**Application for a non-material amendment following a grant of planning permission.
Town and Country Planning Act 1990**

Erection of first floor side and rear extension, single storey rear extension and vehicular entrance gates (within a Conservation Area)

Minor change to roof pitch on front slope of proposed extension over the garage, in order to lower the ridge height. Roof pitch of this slope changed from 33 degs to approx. 26 degs

title elevations & specification as proposed  
number 16026D-06-P01  
scale 1:50  
size A1

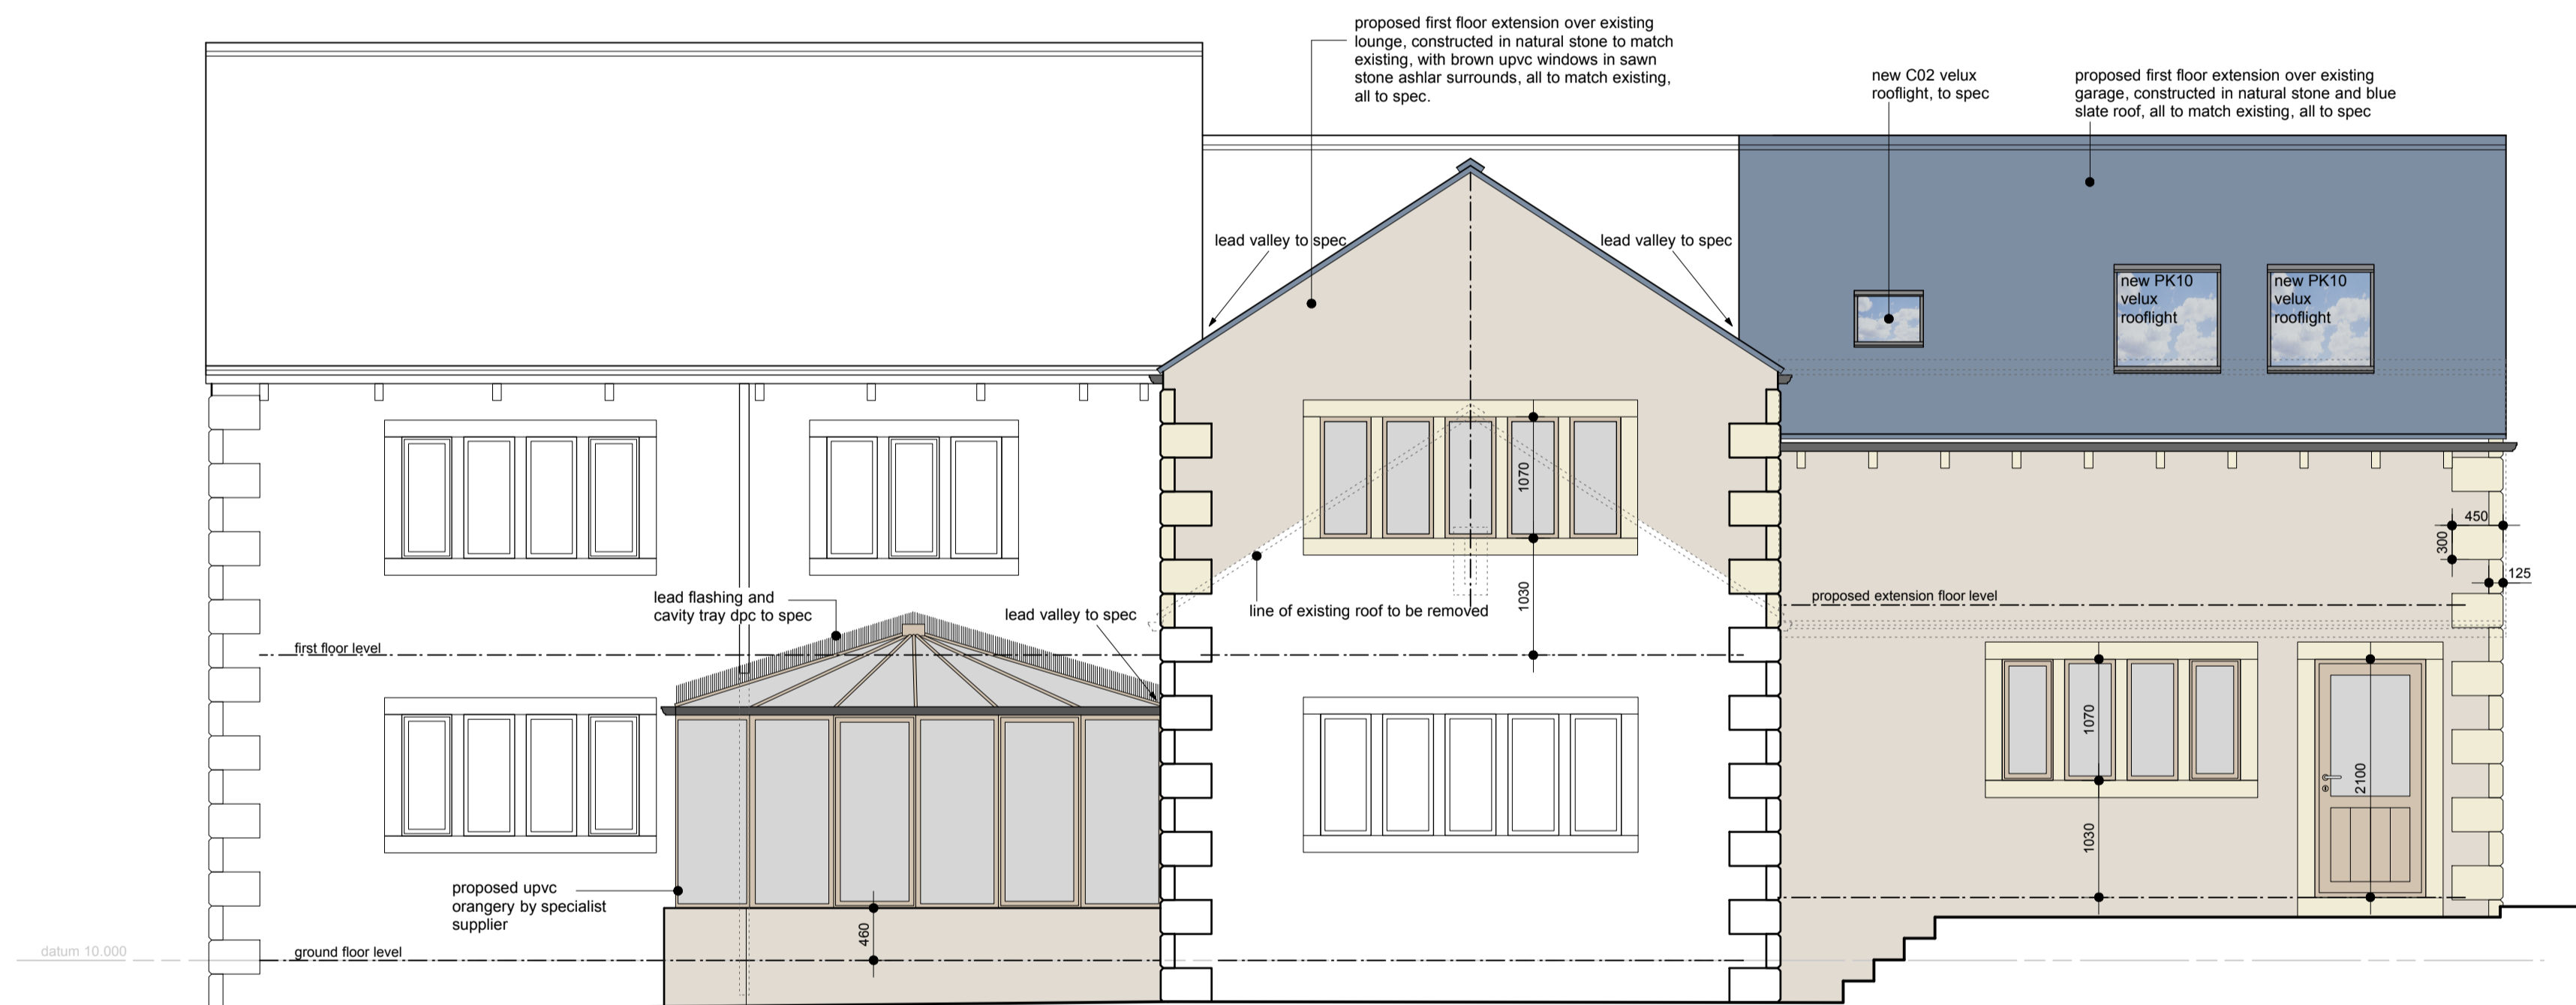
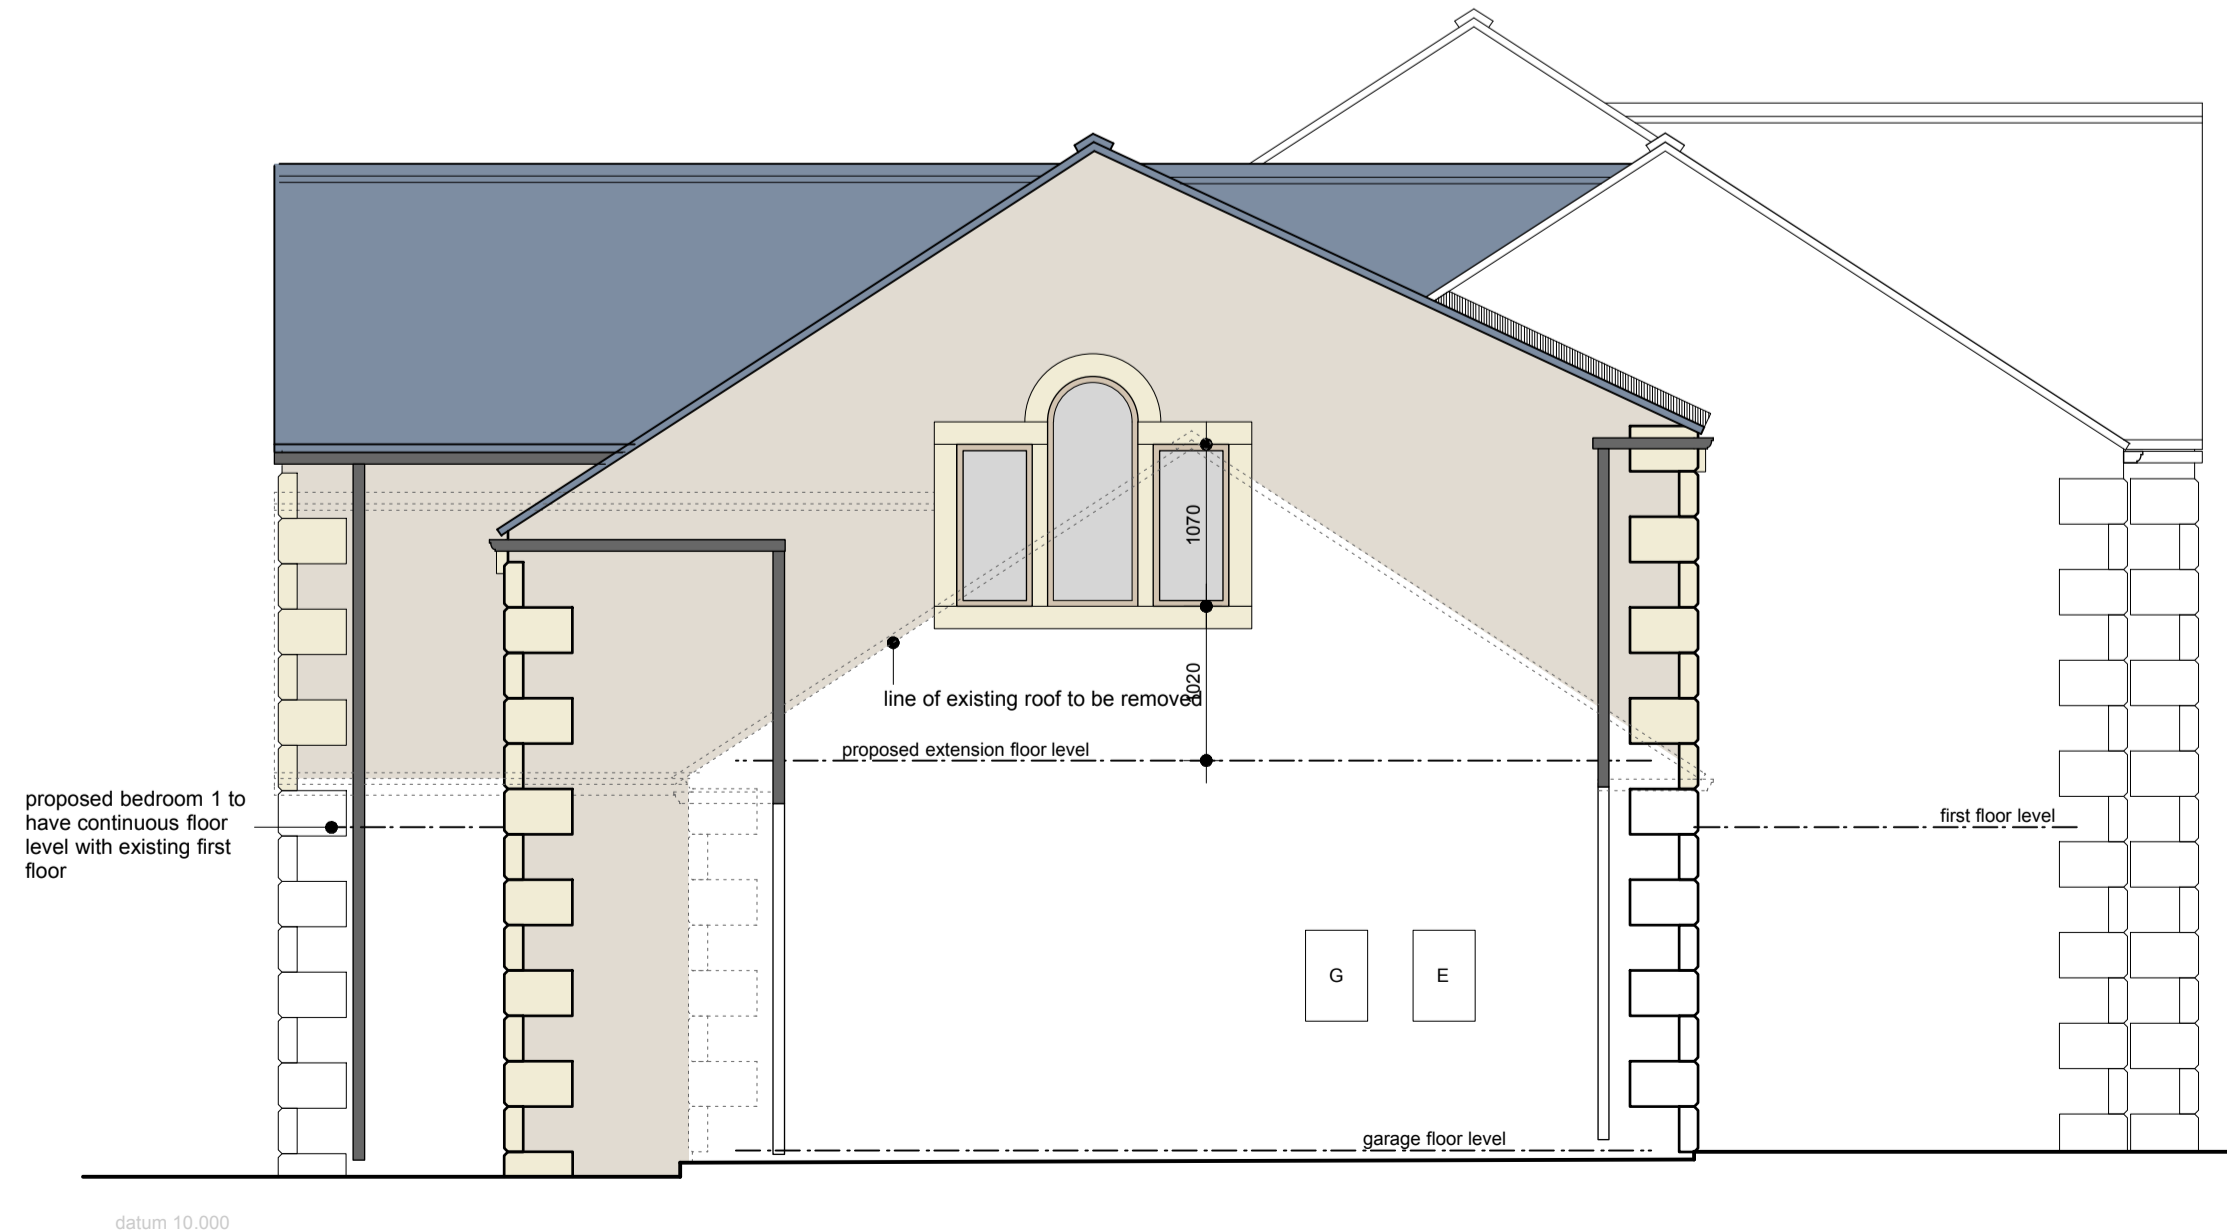
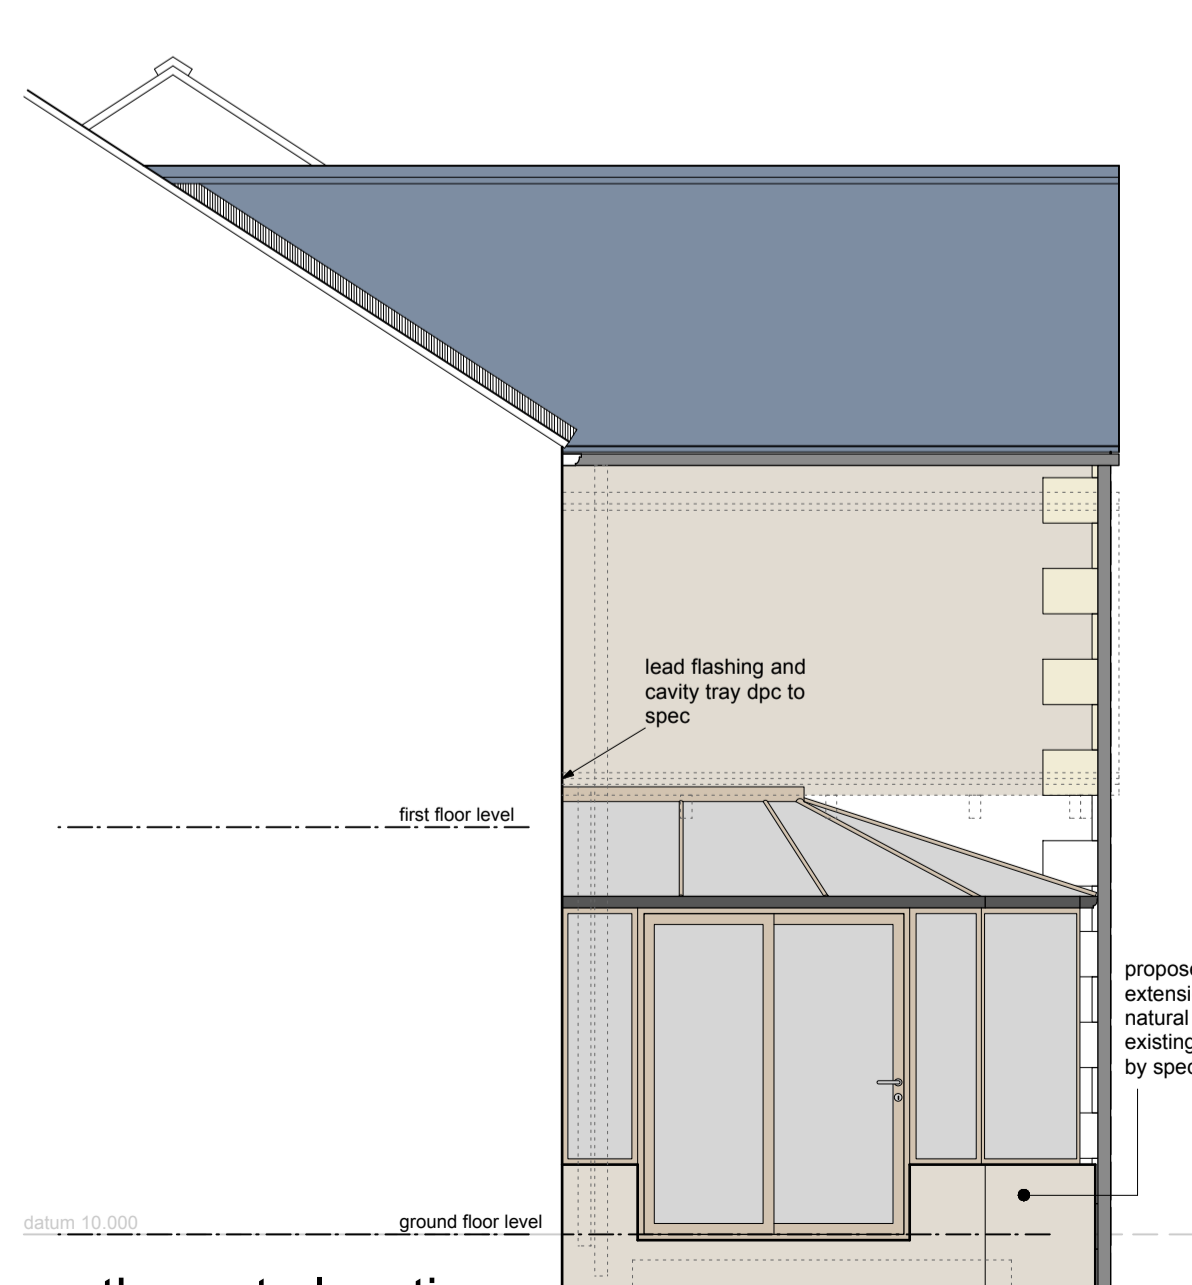
Having carried out a measured survey of the existing house, it was found that the existing information provided to us for the existing house was inaccurate and therefore the proposed ridge height would have been higher than that of the adjacent existing roof. The amendment seeks to keep the proposed ridge height no higher than that adjacent to it.
